# CITY OF ALBUQUERQUE

October 14, 2022

Re: **Gyro Shack**  
**4201 San Mateo Blvd. NE**  
**Traffic Circulation Layout**  
Engineer's/Architect's Stamp XX-XX-XX (G17-D024)

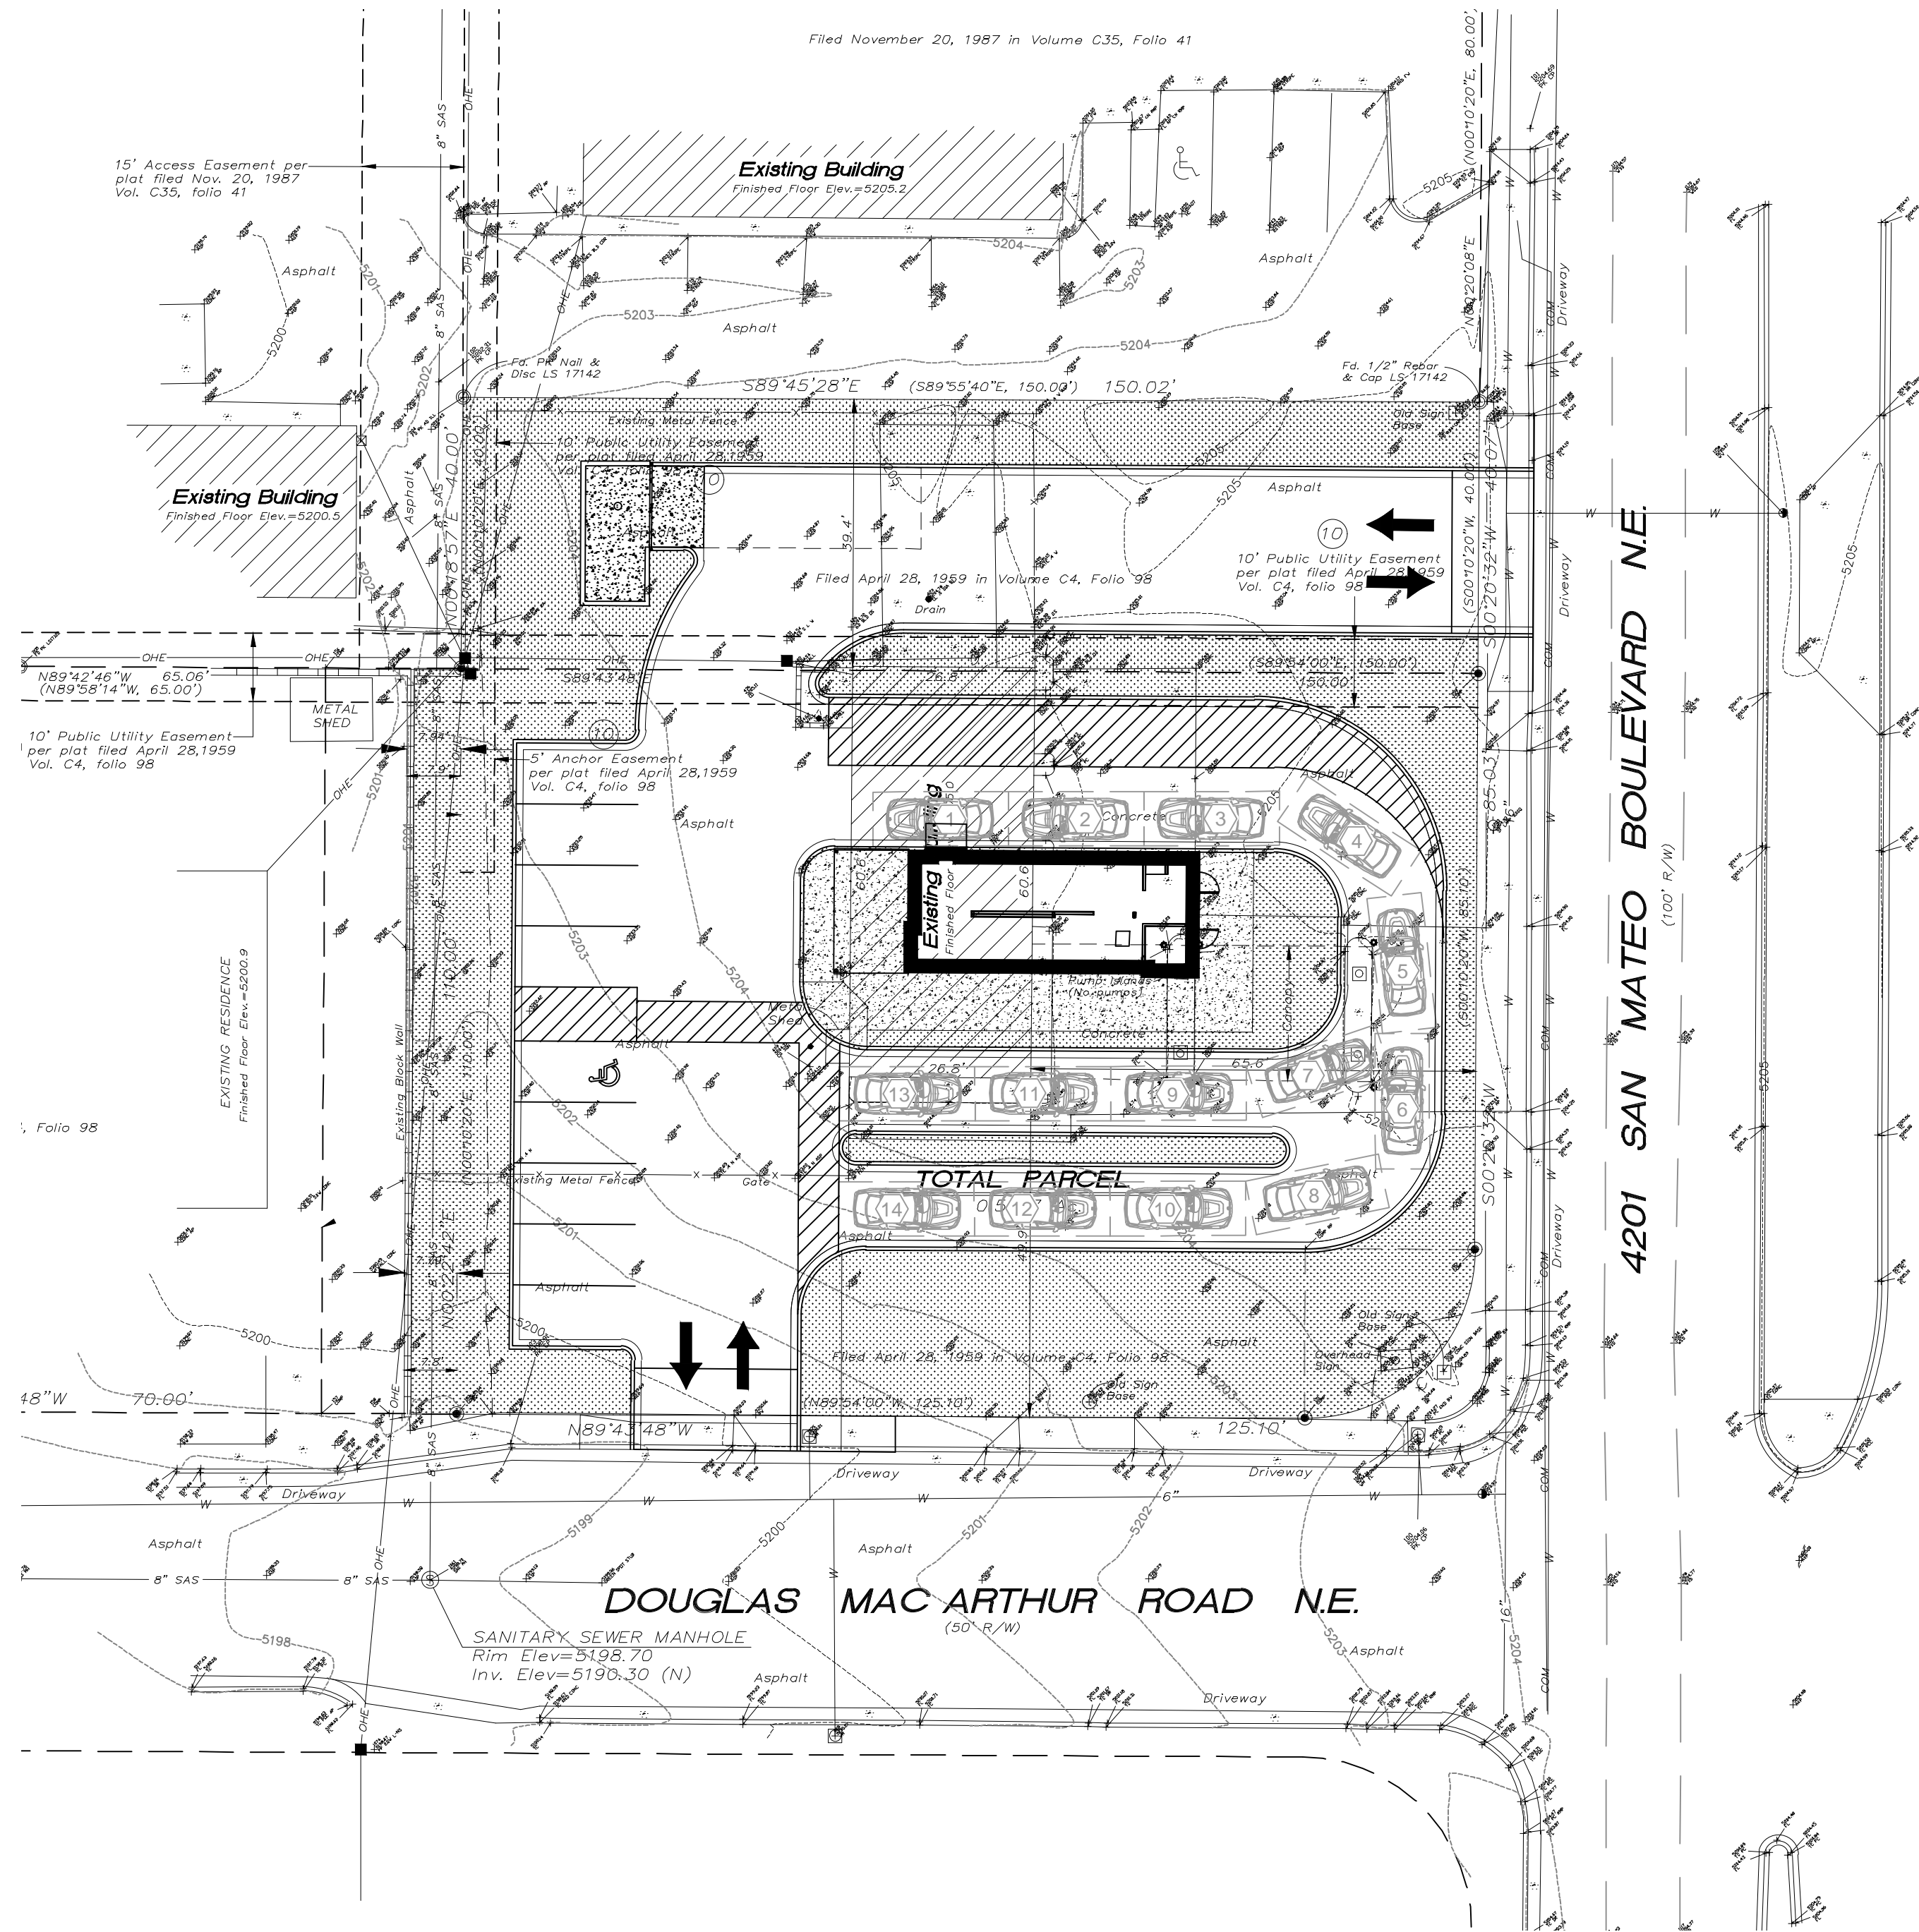
1. List the number of Motorcycles and Bicycles parking spaces required by the IDO.
1. The traffic circulation layout must be stamped, signed, and dated by an engineer or architect licensed in the state of New Mexico.

2. Identify the right of way width, medians, curb cuts, and street widths on San Mateo Blvd. and Douglas Mac Arthur Rd.
3. Clarify existing property lines and proposed property lines.

4. A curb return design is required for the both driveway accesses. Please provide details.
5. The ADA accessible spaces must include an access aisle. Van accessible aisles should be 8ft wide; all others should be 5ft wide.

6. The ADA accessible parking sign must have the required language per 66-7-352.4C NMSA 1978 **"Violators Are Subject to a Fine and/or Towing."** Please call out detail and location of signs.

7. The ADA access aisles shall have the words **"NO PARKING"** in capital letters, each of which shall be at least one foot high and at least two inches wide, placed at the rear of the parking space so as to be close to where an adjacent vehicle's rear tire would be placed. (66-1-4.1.B NMSA 1978)

8. ADA curb ramps at the corner of San Mateo and Douglas Mac Arthur must be updated to current standards and have truncated domes installed.
9. Key note 2: please provide details for the proposed ramp.

10. Motorcycle parking spaces shall be designated by its own conspicuously posted upright sign, either free-standing or wall mounted per the zoning code.

11. All bicycle racks shall be designed according to the following guidelines:
  - a. The rack shall be a minimum 30 inches tall and 18 inches wide.

- 17. Per the IDO, a 6 ft. wide ADA accessible pedestrian pathway is required from the public sidewalk to the building entrances. Please clearly show this pathway and provide details.

- 18. Per DPM, a 6 ft. wide ADA accessible pedestrian pathway is required from the ADA parking stall access aisles to the building entrances. Please clearly show this pathway and provide details.

- 19. ADA accessible pedestrian pathway should not be placed behind parking space or adjacent to a vehicular way. Vehicle and pedestrian/wheel chair conflicts should be avoided as much as possible.

- 20. Curbing should be installed to delineate landscape, parking, and pedestrian ways and identify points of access. Please call out detail and location of barrier curb.

- 21. Parking areas shall have barriers to prevent vehicles from extending over public sidewalk, public right-of-way, or abutting lots.
- 22. Refuse vehicle maneuvering shall be contained on-site. The refuse vehicle shall not back into the public right of way.; provide a copy of refuse approval.

- 23. Provide a copy of Fire marshal approval.
- 24. All one-way drives shall have "One Way" and "Do Not Enter" signage and pavement markings. Please show detail and location of posted signs and striping.

25. The minimum drive through lane width is 12 feet with a 25 foot minimum radius (inside edge) for all turns. (A 15 foot radius can be used with an increase in lane width to 14 feet). Please dimension all lane widths and radii.

26. Please specify the City Standard Drawing Number when applicable.
27. Unused curb cuts must be replaced with sidewalk and curb & gutter. A build note must be provided referring to the appropriate City Standard drawing.

28. Add a note stating "All broken or cracked sidewalk must be replaced with sidewalk and curb & gutter." A build note must be provided referring to the appropriate City Standard drawing.

## BICYCLE RACK

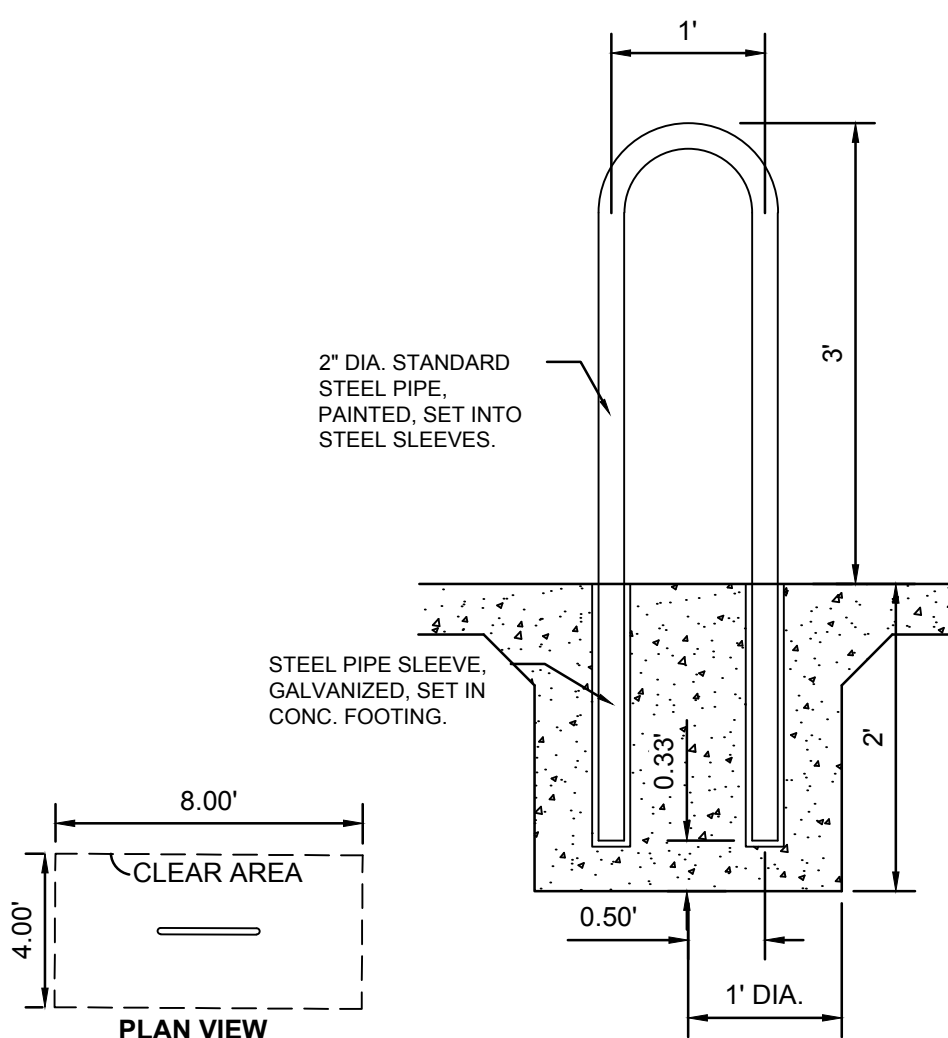
- b. The bicycle frame shall be supported horizontally at two or more places. Comb/toaster racks are not allowed.
  - c. The rack shall be designed to support the bicycle in an upright position. See the IDO for additional information.
  - d. The rack allows varying bicycle frame sizes and styles to be attached.
  - e. The user is not required to lift the bicycle onto the bicycle rack.
  - f. Each bicycle parking space is accessible without moving another bicycle.
- 12. Bicycle racks shall be sturdy and anchored to a concrete pad.
  - 13. A 1-foot clear zone around the bicycle parking stall shall be provided.
  - 14. Bicycle parking spaces shall be at least 6 feet long and 2 feet wide.
  - 15. Show all drive aisle widths and radii. Some dimensions are not shown.
  - 16. The minimum drive aisle dimensions are shown below
